WEST SUSSEX COUNTY COUNCIL CONSULTATION

TO:	Arun District Council FAO: Andrew Wood
FROM:	Highways, WSCC
DATE:	10/05/2018
LOCATION:	30, Lagoon Road, Pagham, West Sussex, PO21 4TJ
SUBJECT:	P/36/18/PL Demolition & erection of 1 No. dwelling with associated vehicle hard standing area.
DATE OF SITE VISIT:	
RECOMMENDATION:	☒ Advice ☐ Objection ☐ Modification ☐ No Objection ☐ More Information ☐ Refusal
S106 CONTRIBUTION TOTAL:	£N/A See below for breakdown.

PROPOSED GROUND FLOOR PLAN

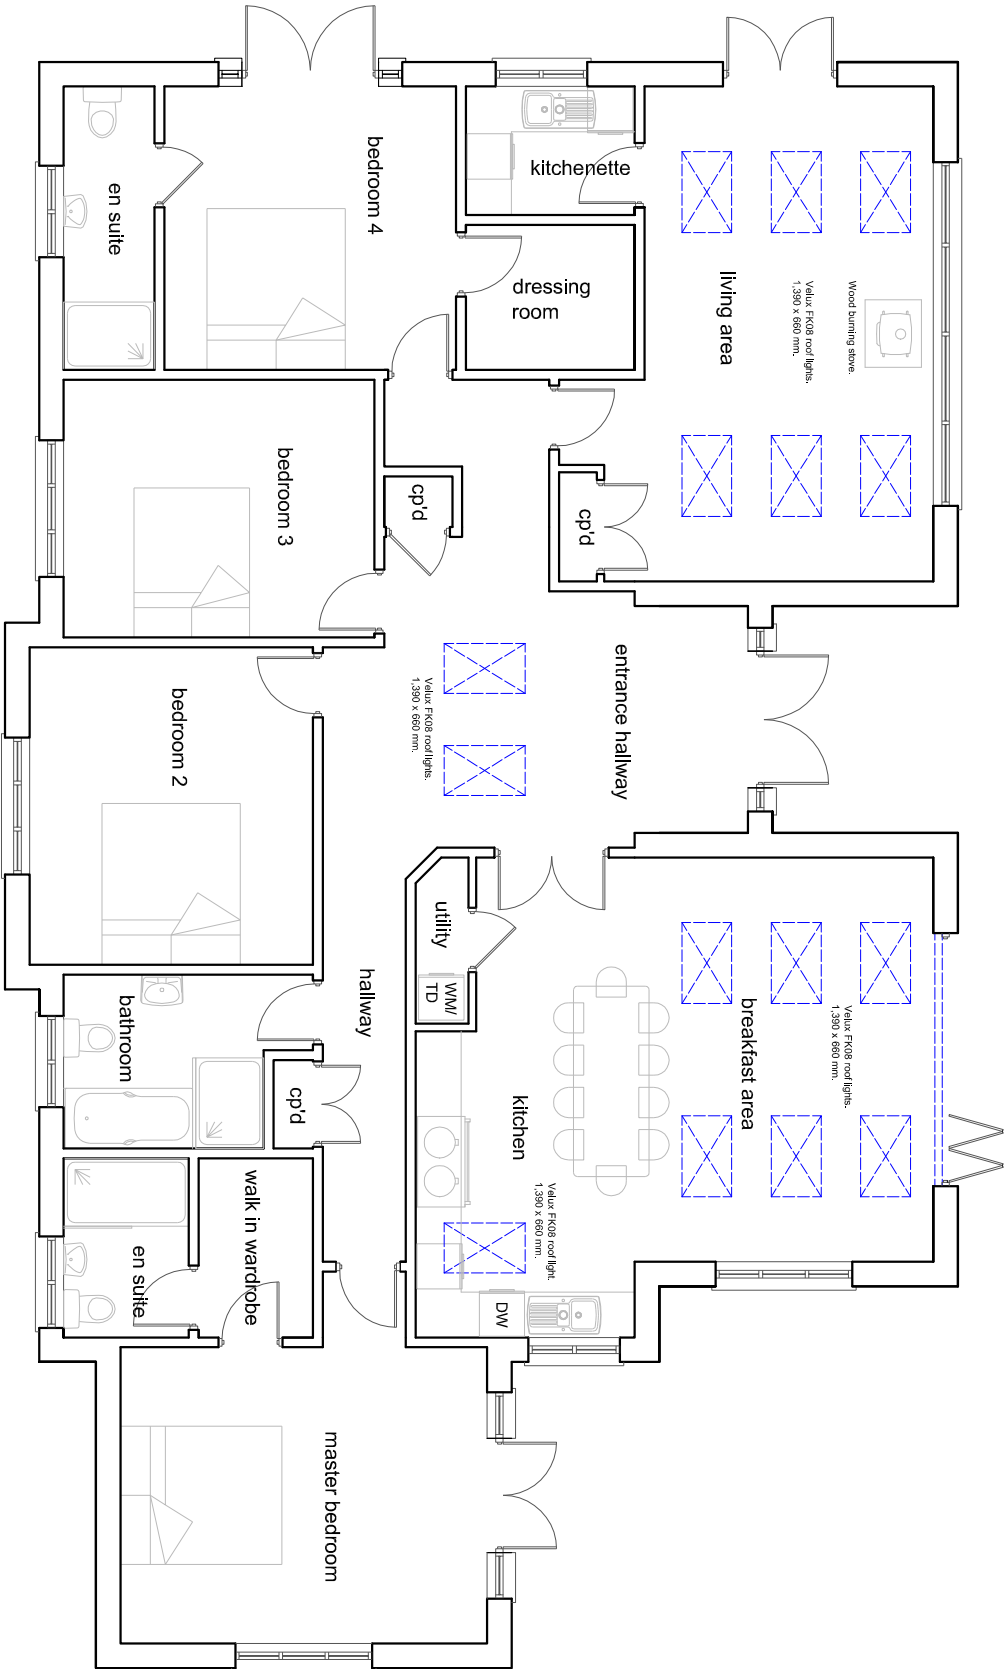
The site is currently accessed via an unmade footpath from Lagoon Road, a privately owned road. The plans show that the applicant plans to create a vehicular access to the site from Wythering Close which is also a privately owned road. The nearest publically maintainable highway is located at the junction between Lagoon Road and Beach Road. The Local Highway Authority (LHA) has reviewed data supplied to WSCC by Sussex Police over a period of the last five years. There have been no recorded injury accidents at the junction between Lagoon Road and Beach Road. There is no evidence to suggest that the junction is operating unsafely, or that the proposed replacement dwelling would exacerbate an existing safety concern.

Before any works to construct the new access can begin, the applicant must seek the relevant permissions from the proprietor of Wythering Close.

By taking approximate measurements from the plans the parking spaces shown do appear to meet the minimum dimensions stated in Manual for Streets (MfS) of 2.4m x 4.8m. The hardstanding area appears to provide enough space for a turn on site to be completed and allow vehicles to exit the site in a forward gear.

The WSCC car parking calculator would envision 3 car parking spaces for a dwelling of this size in this location. The plans only detail the provision of 2 car parking spaces. Whilst on-street car parking is limited in the immediate vicinity there are parking restrictions in the form of single yellow lines, prohibiting vehicles from parking in places that would be detriment to highway safety. We would not consider that highway safety would be

The site is approximately a 5 minute walk from local shops and amenities and a 20 minute bicycle ride to Bognor Regis train station. Therefore the LHA would advise that secure and covered bicycle storage is provided to encourage more sustainable transport methods.

If the LPA are minded to approve this application the LHA would suggest that conditions securing cycle parking and parking and turning are included.
